Advice on Amendment Report & Response to Submissions – State Significant Development

Proposal: Gregory Place Build to Rent

Major Project reference: SSD-31179510

16 January 2026

Figure.123 North Elevation - Landscaped Shared Zone

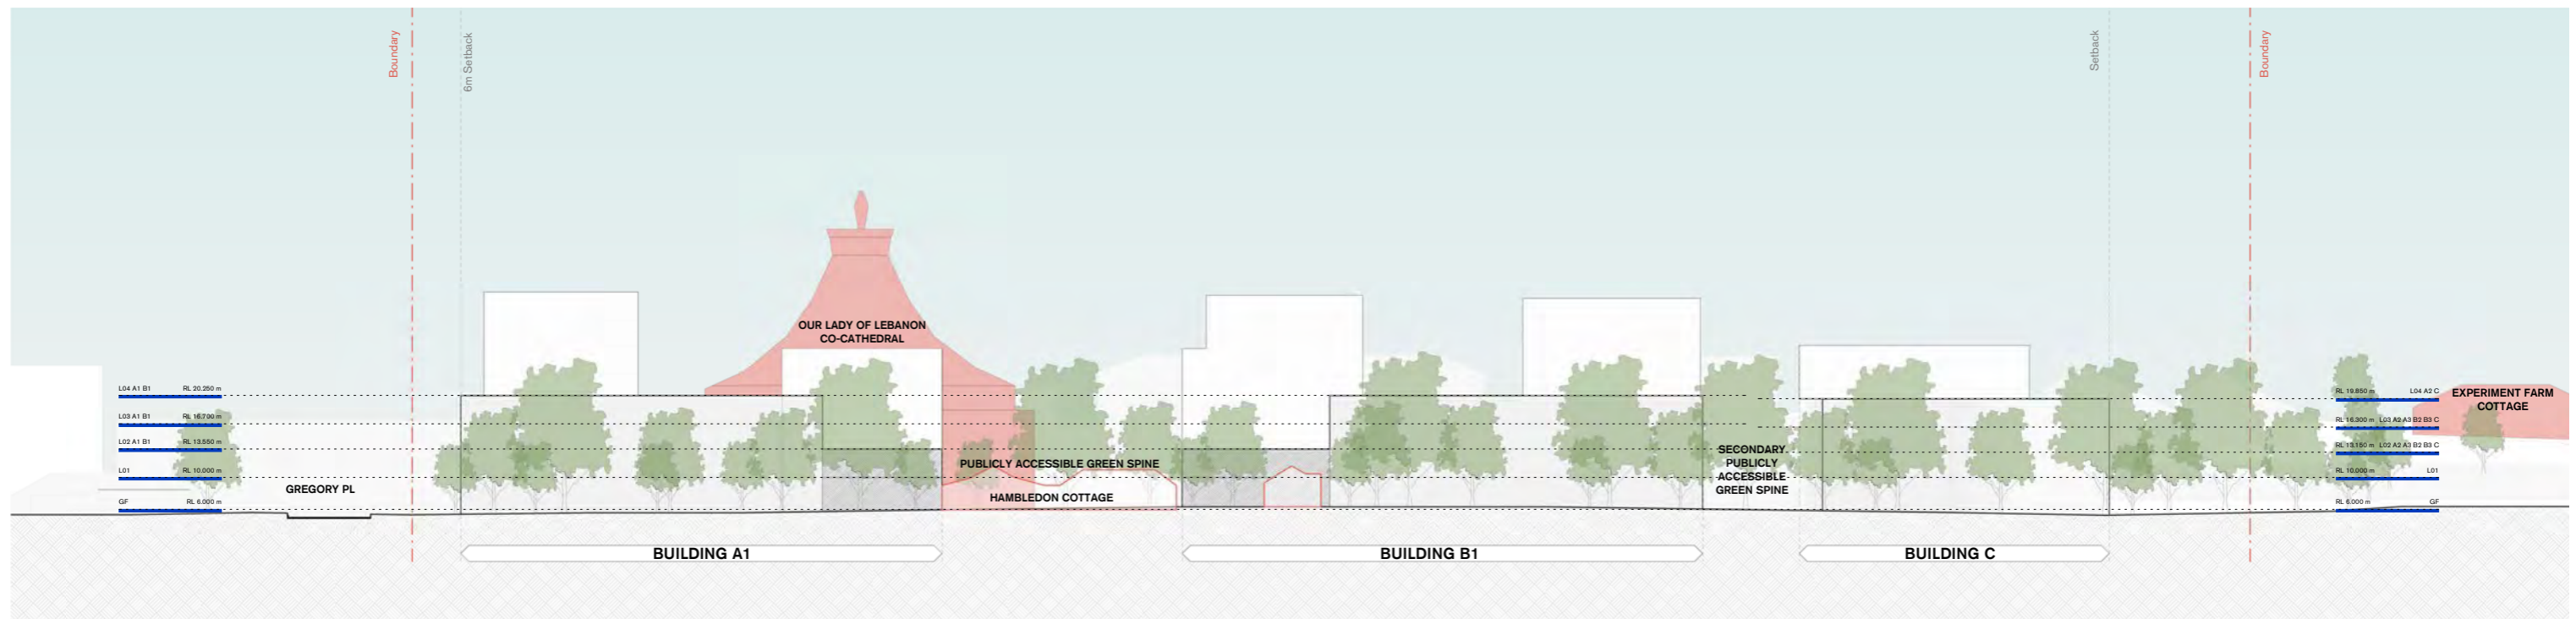
- Later design phases should carefully consider visual impacts on Hambleton Cottage and Experiment Farm. It is recommended that the design should be contemporary in character but sympathetic in colour and materiality and should not detract from or visually overwhelm the SHR listed items in the vicinity. Detailed design should also consider breaking down of visual mass as noted in Item 9 of the Approvals Committee resolutions (Attachment A);

8. **Support** the proposed current scheme with a maximum of 2-storey heights for buildings in the immediate vicinity of the Hambledon Cottage.
9. **Consider** in later design phases breaking up the visual mass, particularly on the northern elevation.
